**RE: Sonata Unit 4 Trails Apartments  
Tracts 1, 2, and 3, The Trails Unit 4  
Third DRB Submittal**

RESPEC, agent for Sonata Trails, LLC, owner of the above referenced property, is requesting approval from the Development Review Board (DRB) on this Site Development Plan submitted for your consideration. This is the second submittal to the DRB for this project. The first hearing was held on June 3, 2020. Below is a response to comments received at the first DRB meeting.

THIS DRAWING IS INCOMPLETE AND NOT TO BE USED FOR CONSTRUCTION UNLESS IT IS STAMPED, SIGNED AND DATED

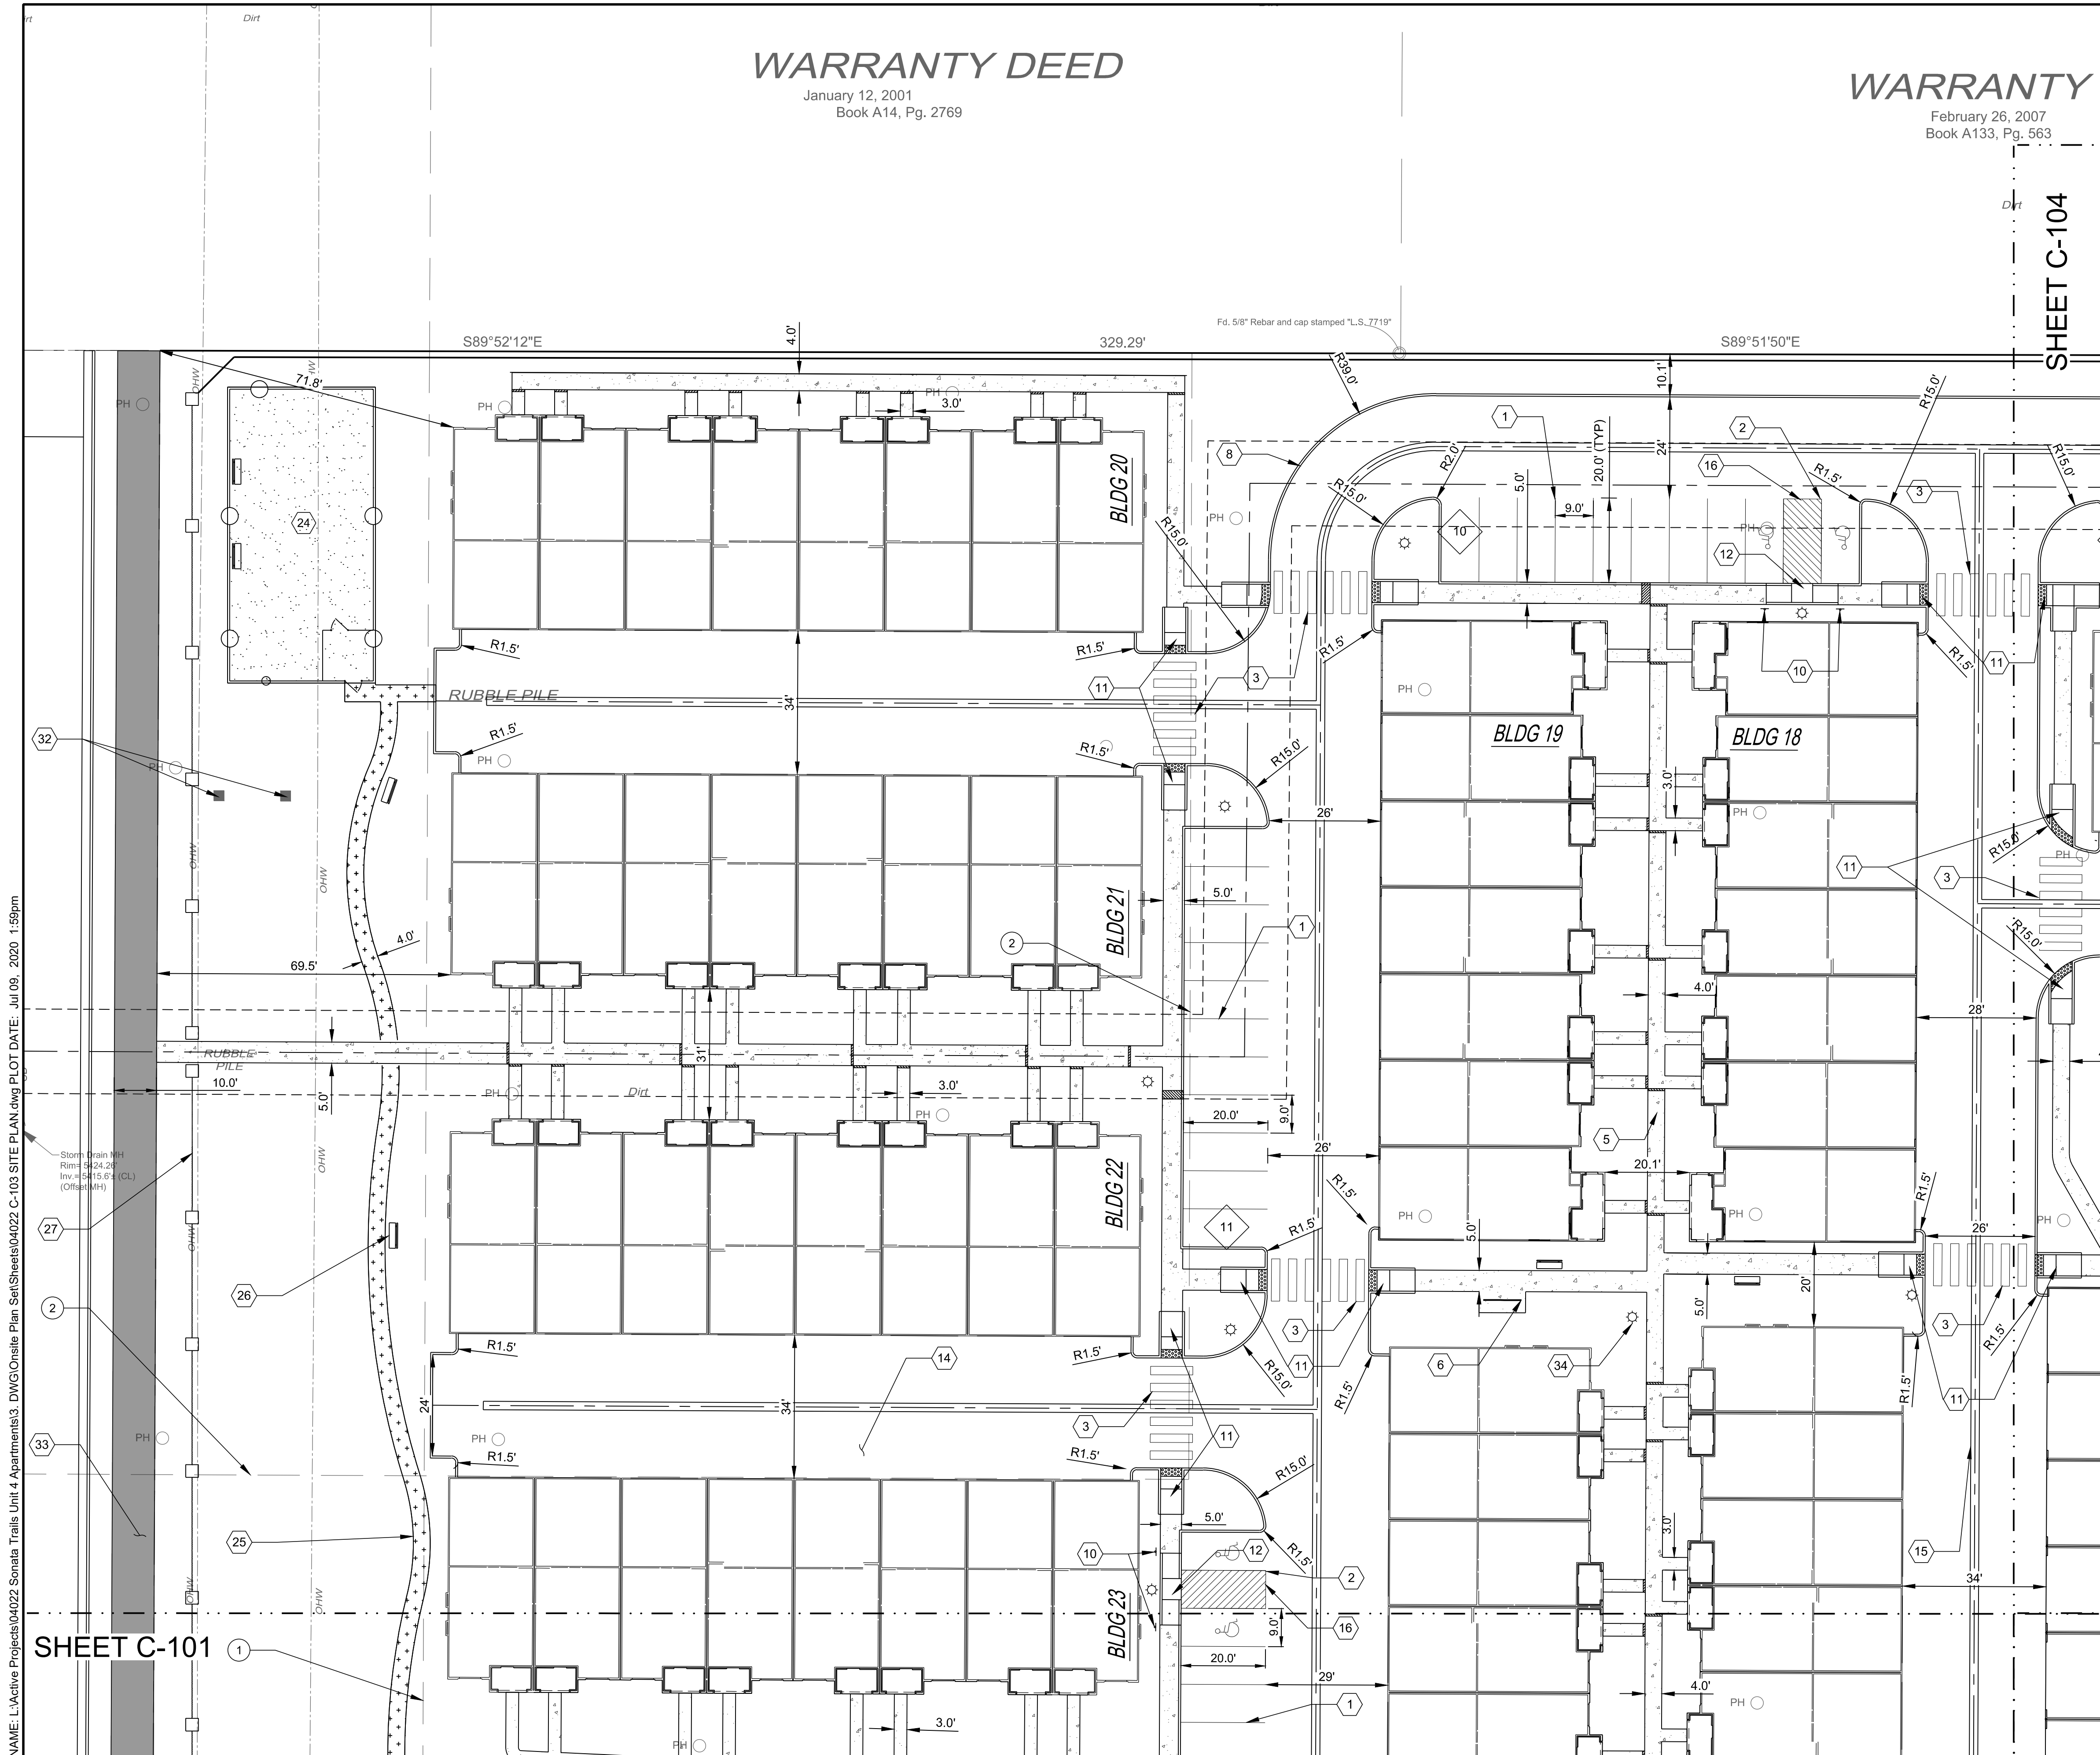
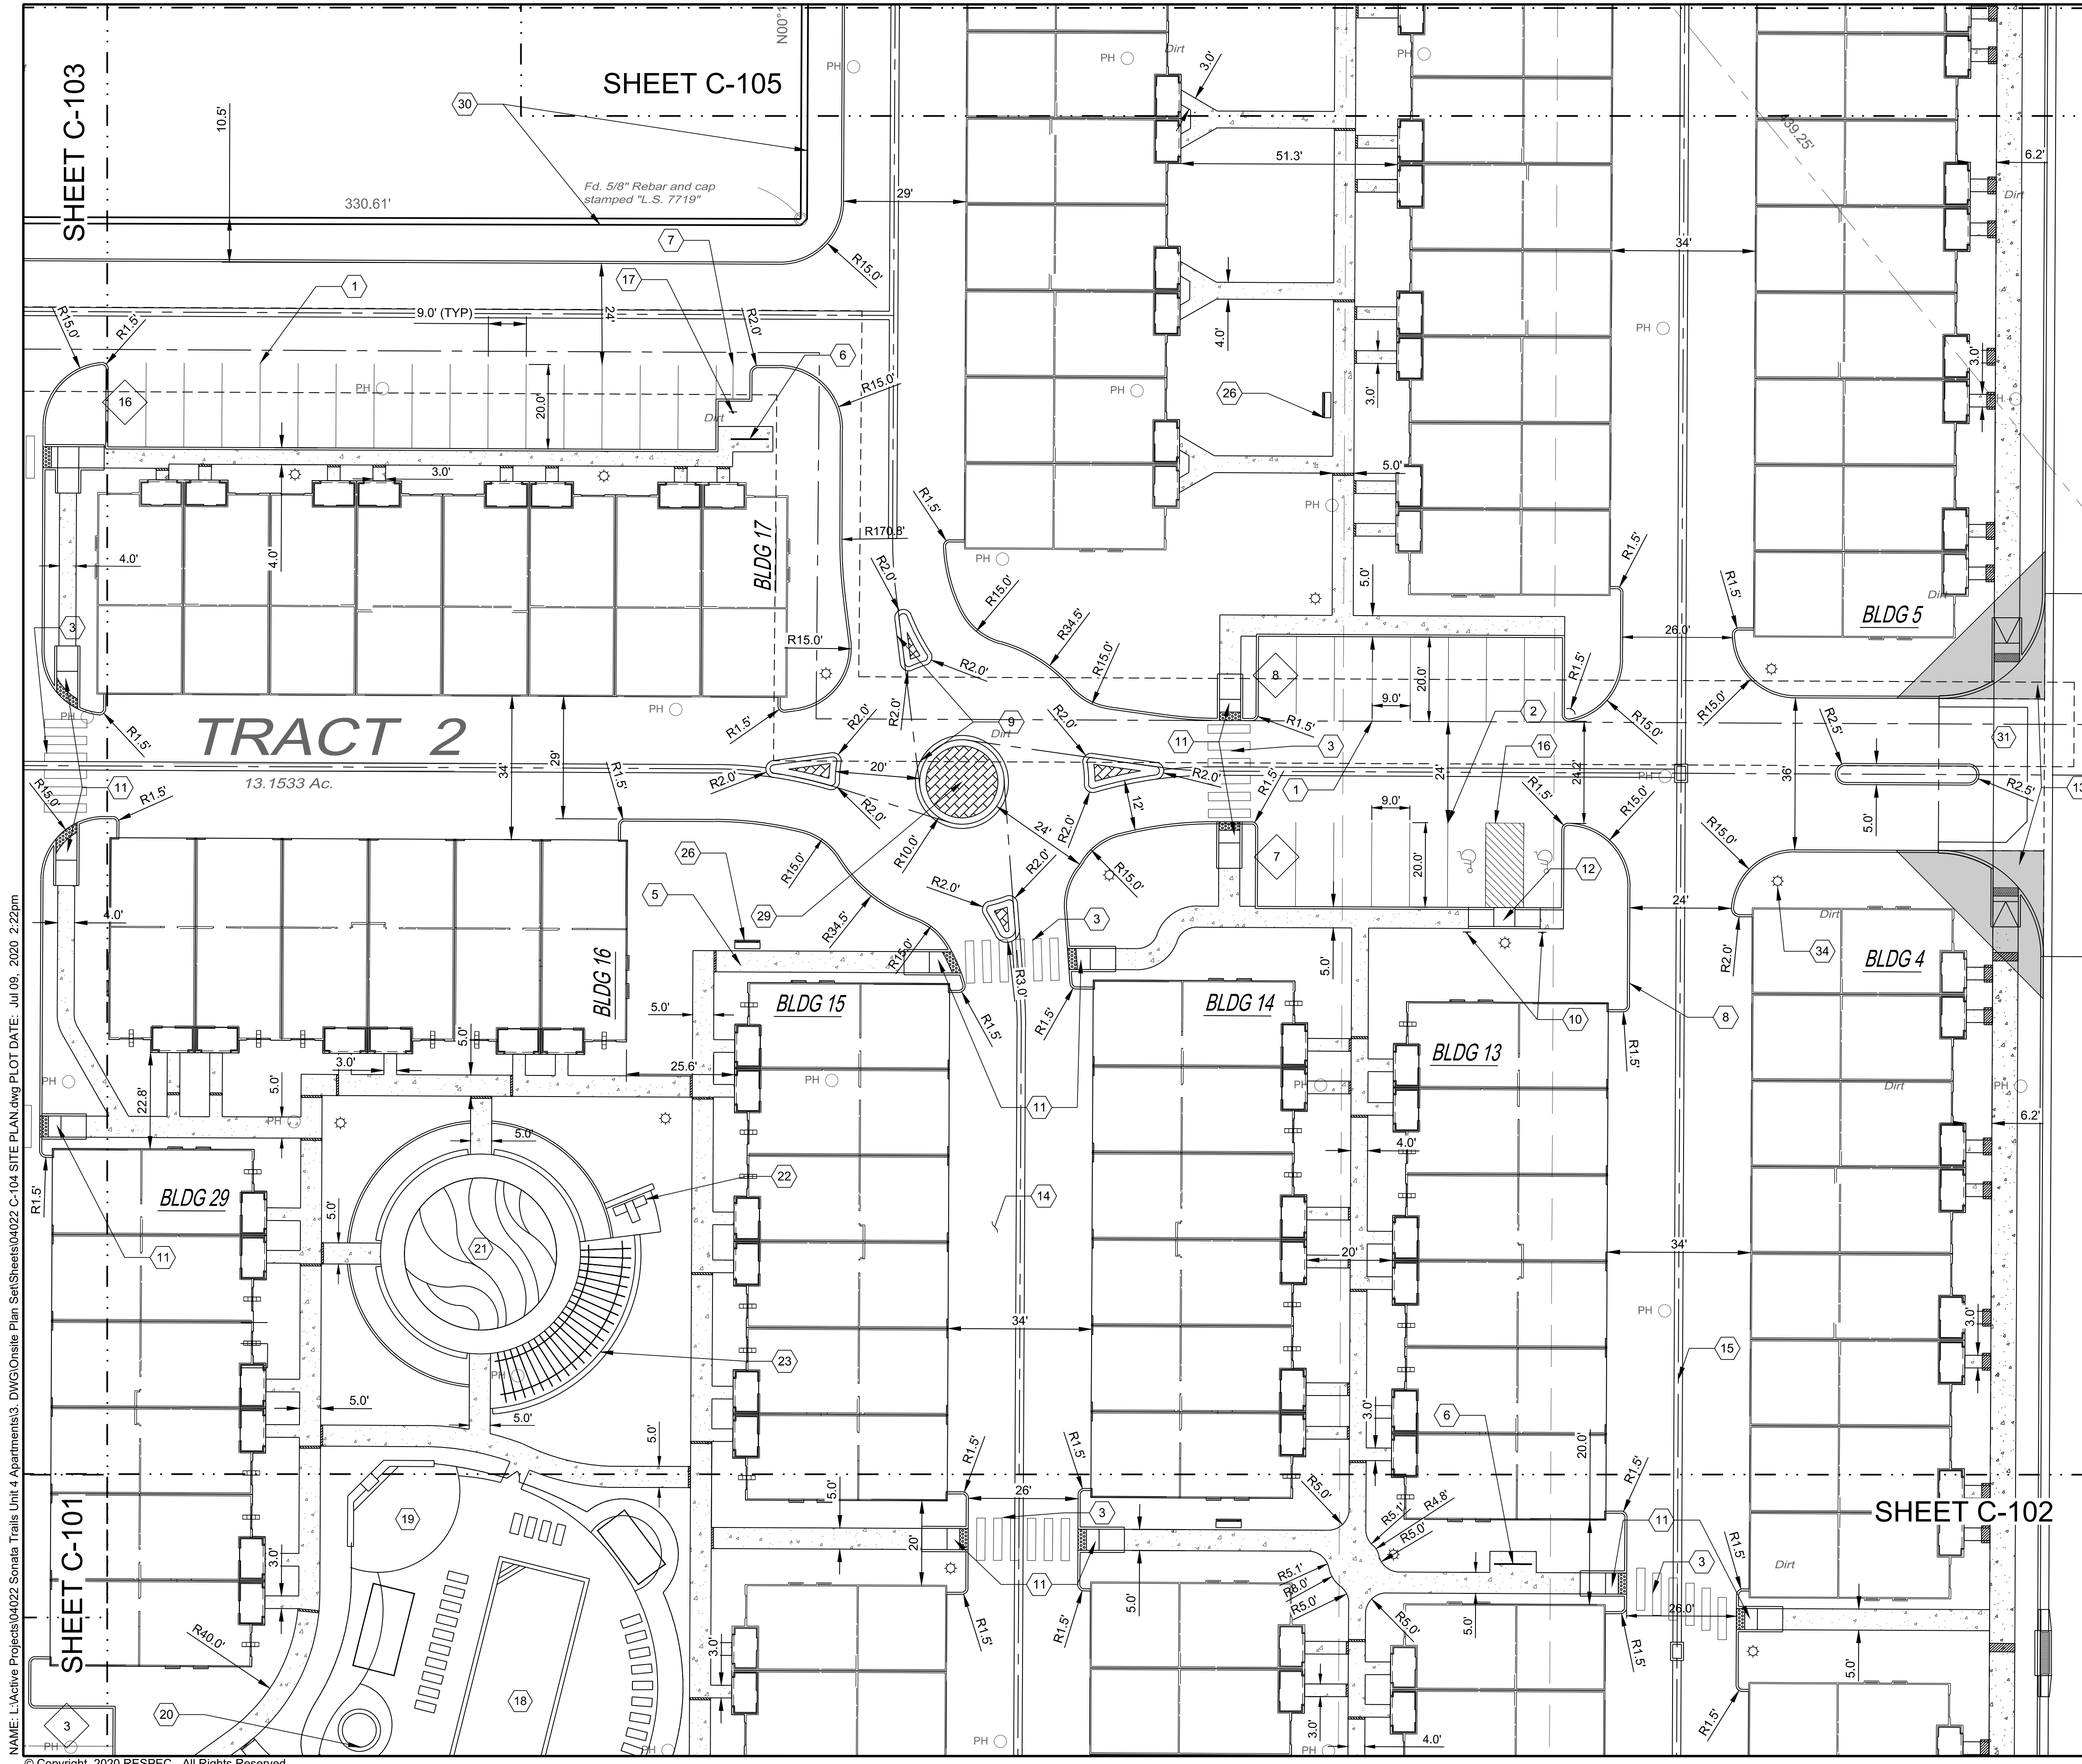
3. Show Oak Ridge limits on infrastructure list. Because roadway improvements are required along the entire length of the site, Chatsworth construction limits should end at Oak Ridge.  
/ Oak Ridge and Chatsworth added to infrastructure list. See revised infrastructure list.

4. Add keyed notes for all ADA ramps on the site plan.  
/ Keyed notes added for all ADA ramps. See revised site plan sheets.
5. Provide motorcycle parking sign detail.  
/ Motorcycle parking sign detail provided. See revised detail sheets.

6. A 6-foot minimum sidewalk width shall be provided from main building to right-of-way and from handicapped spaces at main building to building entrance. (The width shown is 5 feet.)  
/ The 6' ADA path provided is at the western-most sidewalk connection to Tree Line Ave, then heads north across the drive aisle and turns east until reaching the clubhouse building.

7. Add a keyed note for crosswalks on the site plan.  
/ Crosswalk keyed note provided. See revised site plan sheets.

8. Add a keyed note for clear sight triangles on both landscaping and site plan.  
/ Keyed note for clear sight triangles provided. Also added at public intersections. See revised landscape and site plan sheets.
9. Dimension all parking spaces. All curb radii need to be labeled.  
/ All parking spaces and curb radii have been dimensioned and labeled. See revised site plan sheets.
10. Provide roadway cross-section for Woodmont prior to second phase of development.  
/ Acknowledged. A roadway cross-section for Woodmont will be provided when Tracts 3 and 4 to the south develop.

- In addition to seeing the plat and right-of-way dedication, he wants to know what the ultimate design will look like both at the Treeline intersection and at the Oak Ridge intersection even though you are expected to just build your half. He wants a clear picture of right-of-way dedication and making sure that it is workable. He wants to know what you are dedicating and what is proposed for dedication for other future developers.  
/ Future roadway linework added for clarity on right-of-way dedication. See revised site plan sheets.

- I believe on Treeline, he was unclear about the design. It might help to just show that temporary transition length when you go from a full road section to a half road section.  
/ Temporary transition length from full to half section labeled. See revised site plan sheets.
